**SYDNEY METRO CHATSWOOD TO SYDENHAM (SSI 15\_7400)  
Track Attenuation and Operational Ground-borne Noise Review  
(Condition D9)**

This letter documents the findings of the final part of my independent review of the proposed design objectives and track attenuation for ground-borne noise, in accordance with Condition D9 of planning approval SSI 15-7400.

The scope of this letter addresses the section of the Sydney Metro tunnels between Crows Nest and Waterloo, which was excluded from the first part of my review<sup>1</sup> because the ground-borne noise and vibration modelling had not been completed at that time.

Figure 11-1a Extent of indicative track form in Sydney Metro Chatswood to Sydenham tunnels Map 1

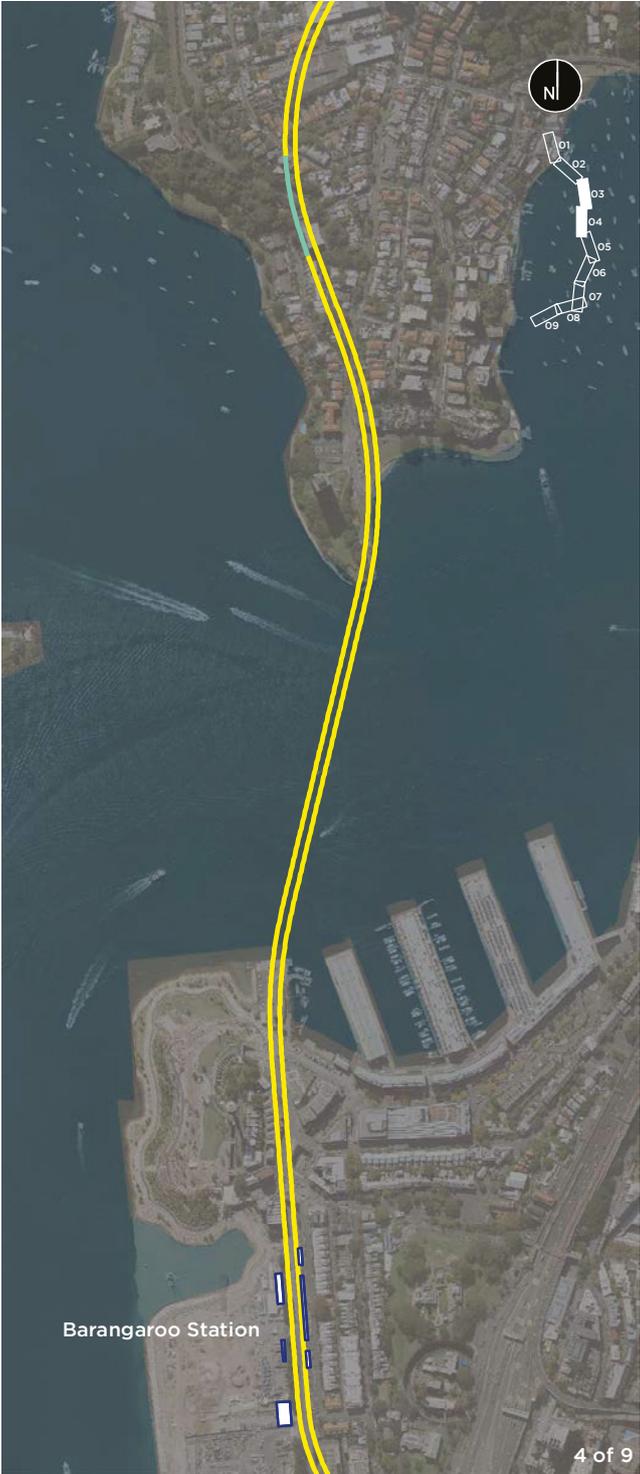
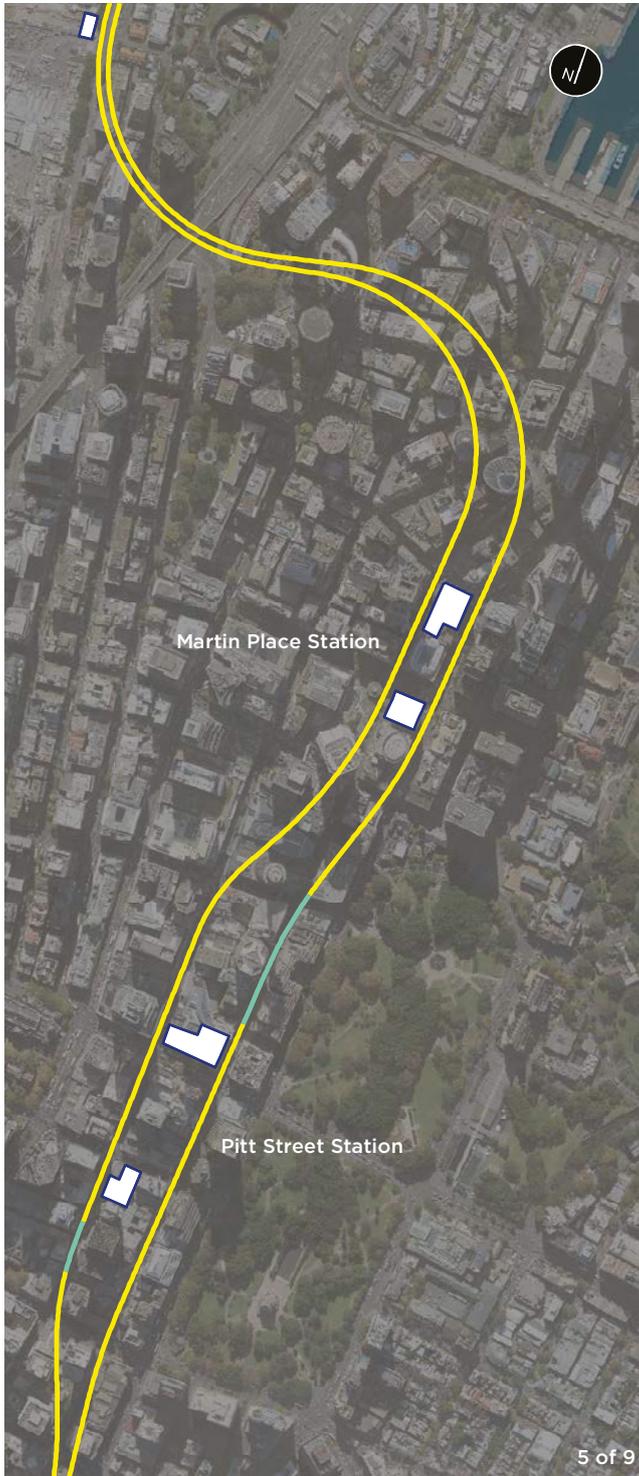
The EIS assumed three levels of track attenuation: standard, high and very high. Based on the modelling carried out at that time, the EIS concluded that standard track attenuation would be sufficient for around 90% of the alignment but recommended high track attenuation for around 8% of the alignment and very high attenuation for the remaining 1 or 2%.

Sydney Metro's final design for track attenuation adopts the very high attenuation system for the majority of the alignment, which means that the outcomes will surpass the recommendations of the EIS at most locations. Standard attenuation track will be used for the parts of the alignment that are not close to sensitive receivers (such as near Central Station and below the harbour); this is consistent with the EIS assumptions in these locations.

I am satisfied that the track attenuation design is consistent with (and for the most part significantly better than) the recommendations in the EIS.
